Please ask for: Sian Eggington
Email: sian.eggington@terraquest.co.uk
Telephone: 0121 2341390
Our Ref: EP/100/20/HH
Your Ref:
Date: 27th August 2020

Application for Planning Permission for Works or Extension to a Dwelling

Development: Car width hard standing block paved surface for car on front garden
Location: 10 Copse View East Preston BN16 1AY

10 Copse View, East Preston, Littlehampton, BN16 1AY

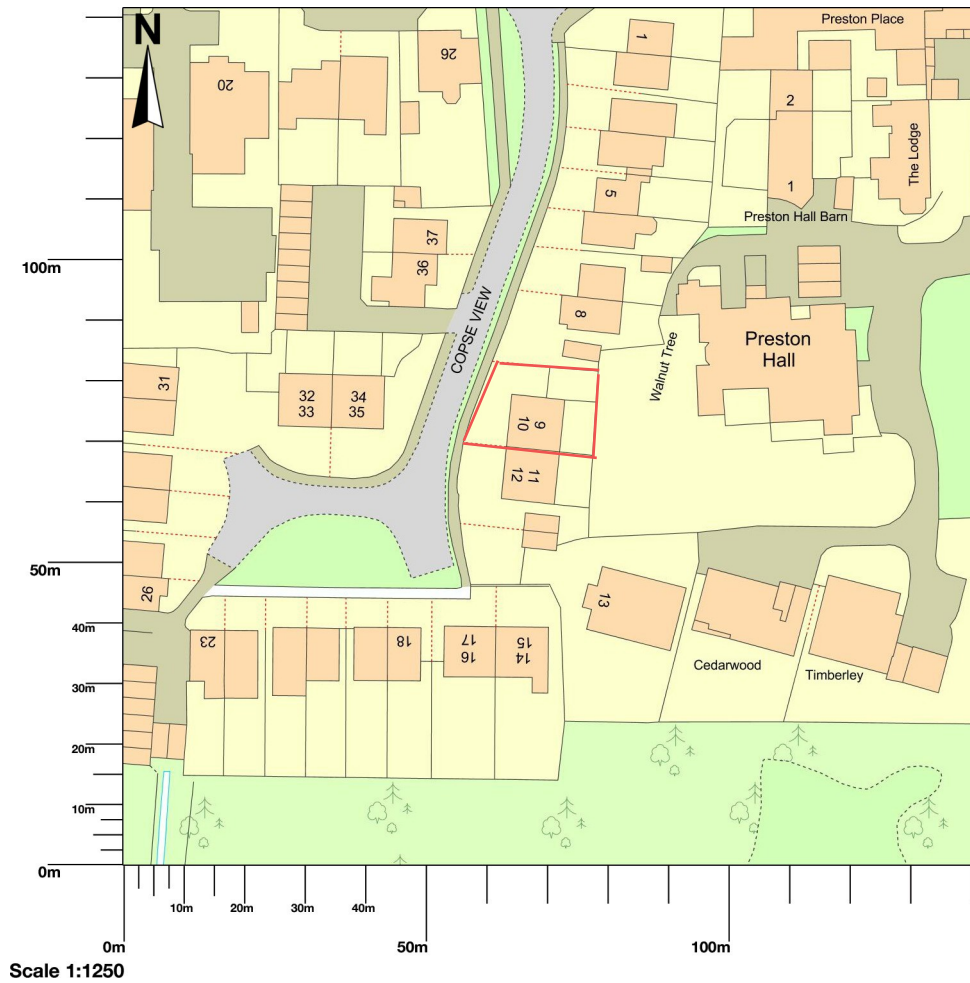
Location Plan: You are required to have a solid red outline around the proposed site on the location plan. Please amend,
